Appeal NO: ABP 321465

Re: St. Margaret's Recycling & Transfer Centre Ltd ABP321465

DRAINAGE LAYOUT

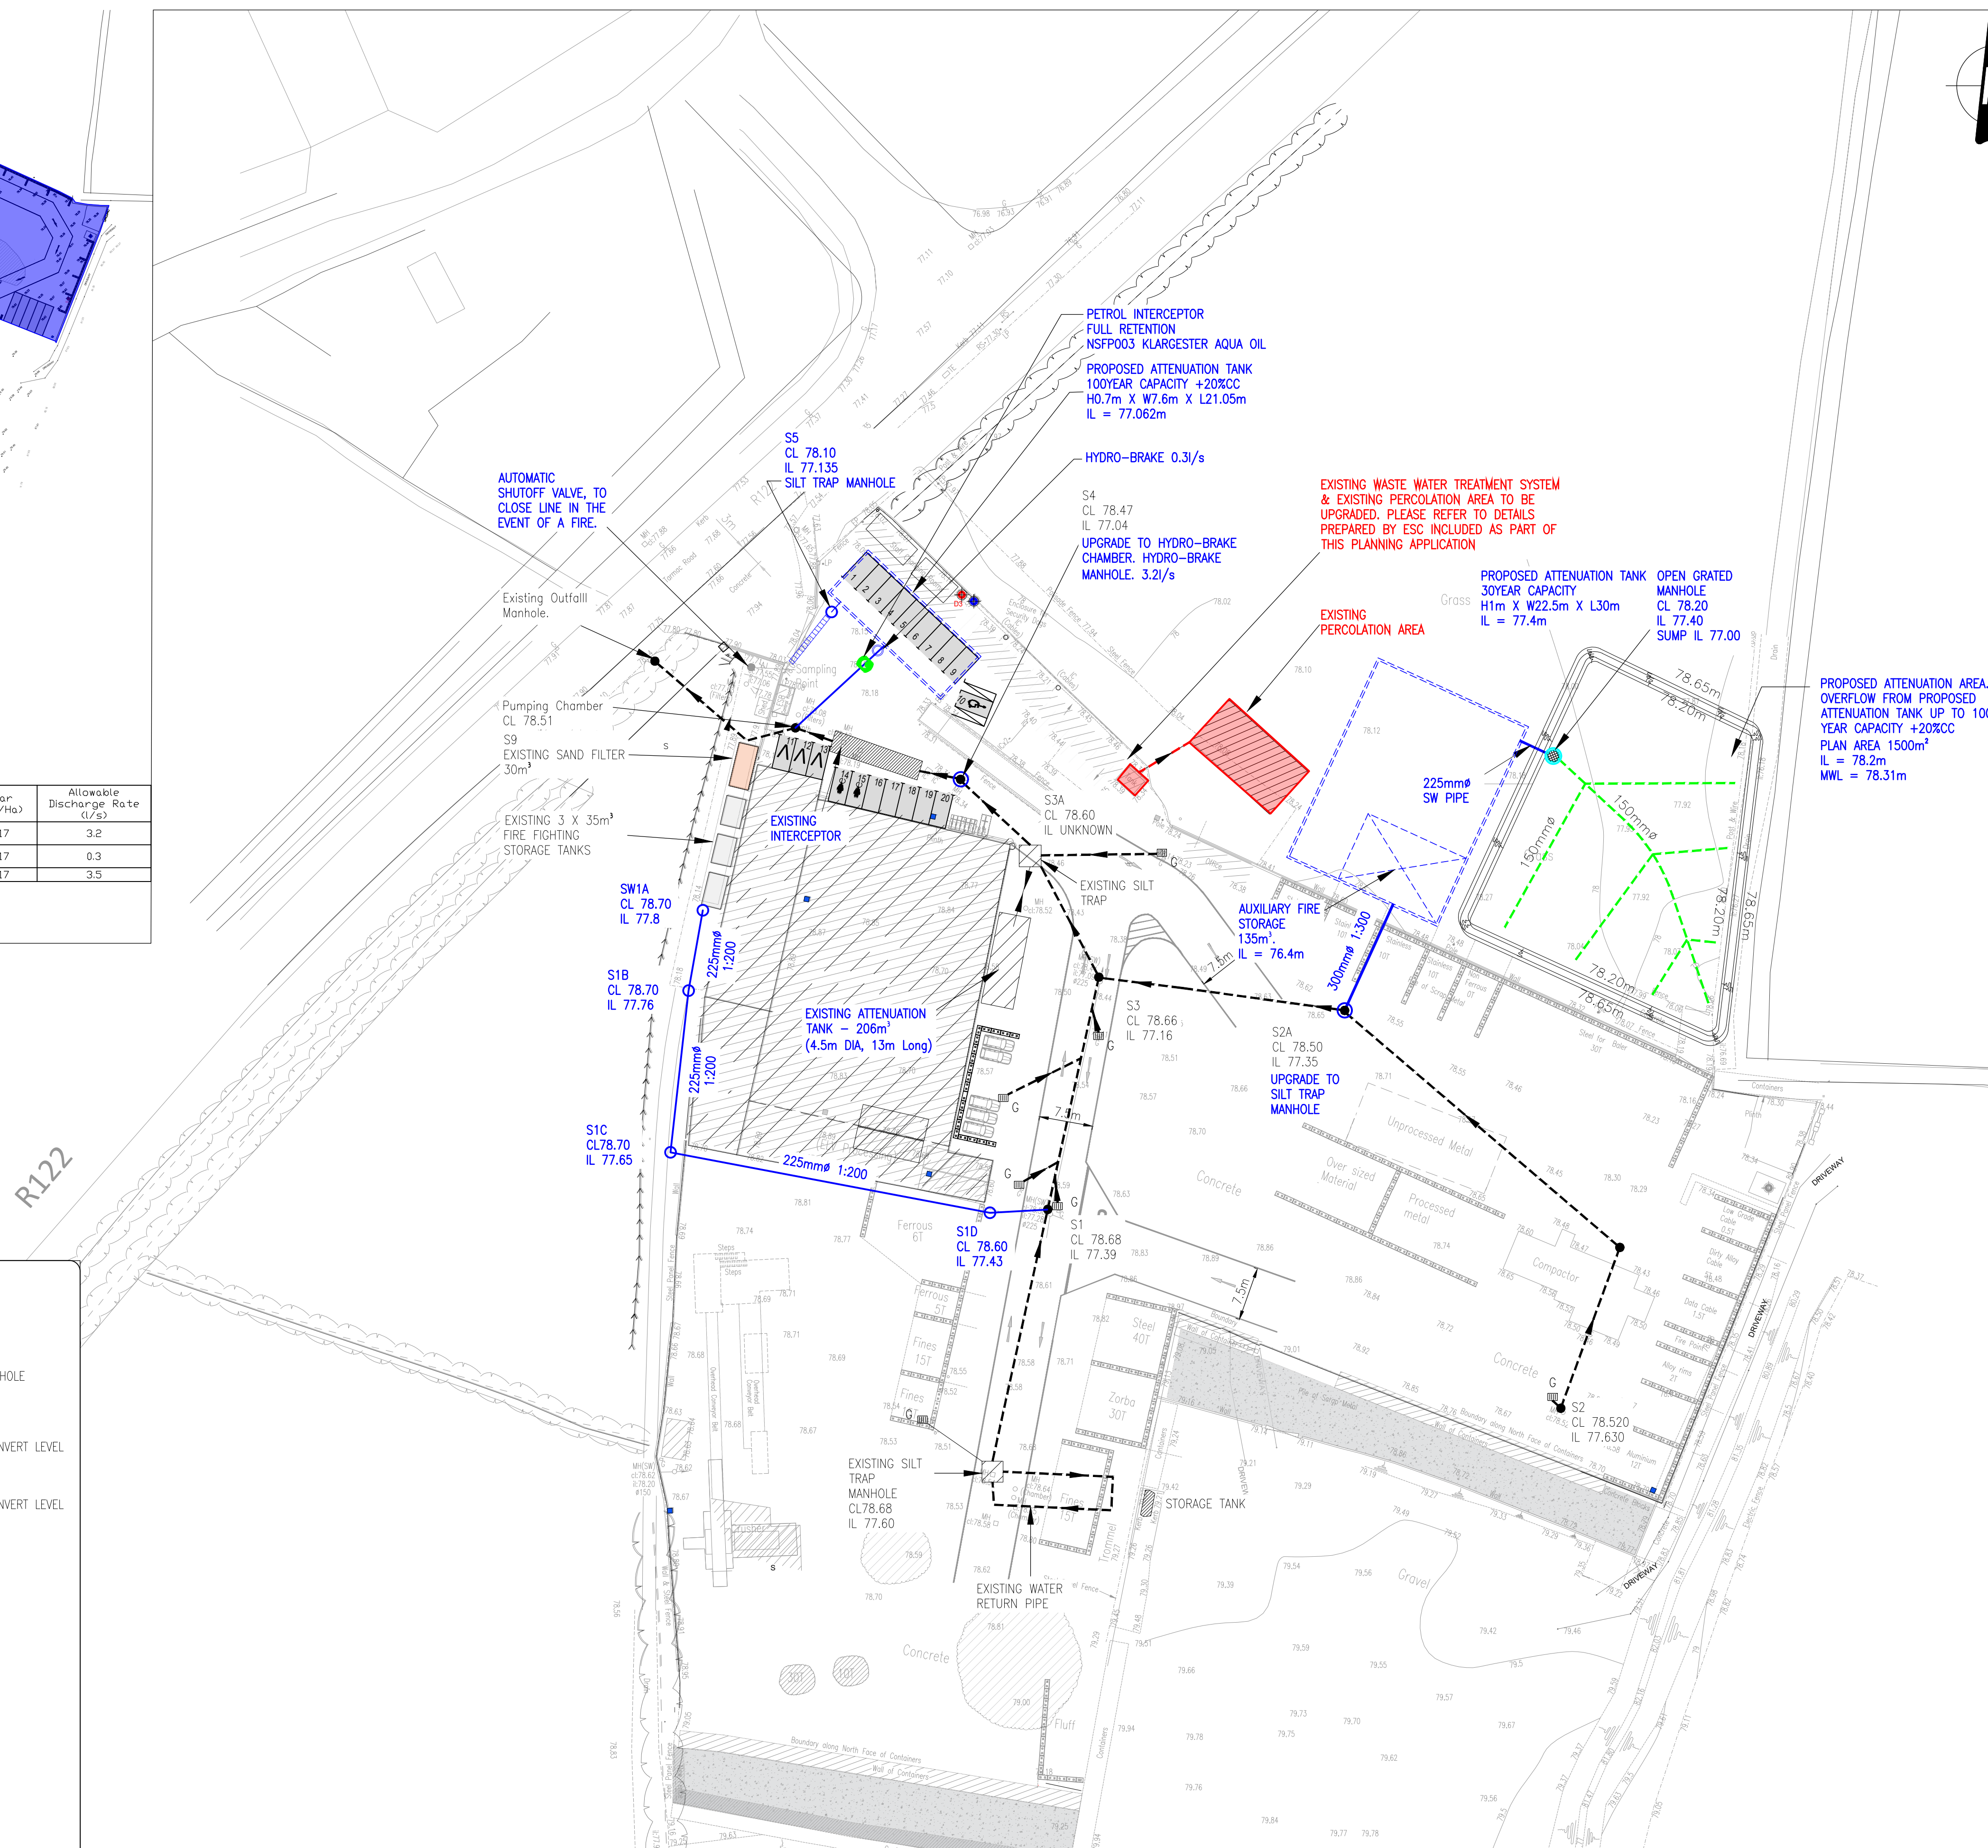
I was never aware of the fact that the surface water from the facility is allowed run directly into an open ditch without reasonable treatment through a bona fide water treatment process on the site, I was in the area when there was a major fire incident at the site and I have seen the emergency services visit the site on occasion. I have never brought material to the site, but I have noticed all sorts of trucks, vans, cars, tractors and trailers and big articulated trucks

The idea that the facility would self-manage its own pollutants and that any government agency would allow or even risk allowing the water that would emanate from such a facility be allowed pass directly into a ditch and culvert feeding the Huntstown stream seems ludicrous. We have seen over the last few days the effect of an oil spillage from a fuel tank delivery one of our National Banks on the south side of Dublin and the spillage entering the lake and stream of the nearby water system The Bank responsible for this particular fuel tank spill, Bank Of Ireland, apologise for this spillage but the damage has already been done, including water life, fauna, and Water fowl.

I believe that if this facility is allowed to continue the water treatment should be of a standard that creates no potential risk and therefore should have a treatment works contained within the facility. This would be a better option than expecting pollutants to dissipate through the use of ground water charging. I am disappointed that regardless of who the applicants are that such risks were not covered in their environmental reports, highlighting really that the safeguards that the Department of Housing now rely on the Commission to impose restrictions, to an extent to prevent pollution, downstream and the Malahide estuary.
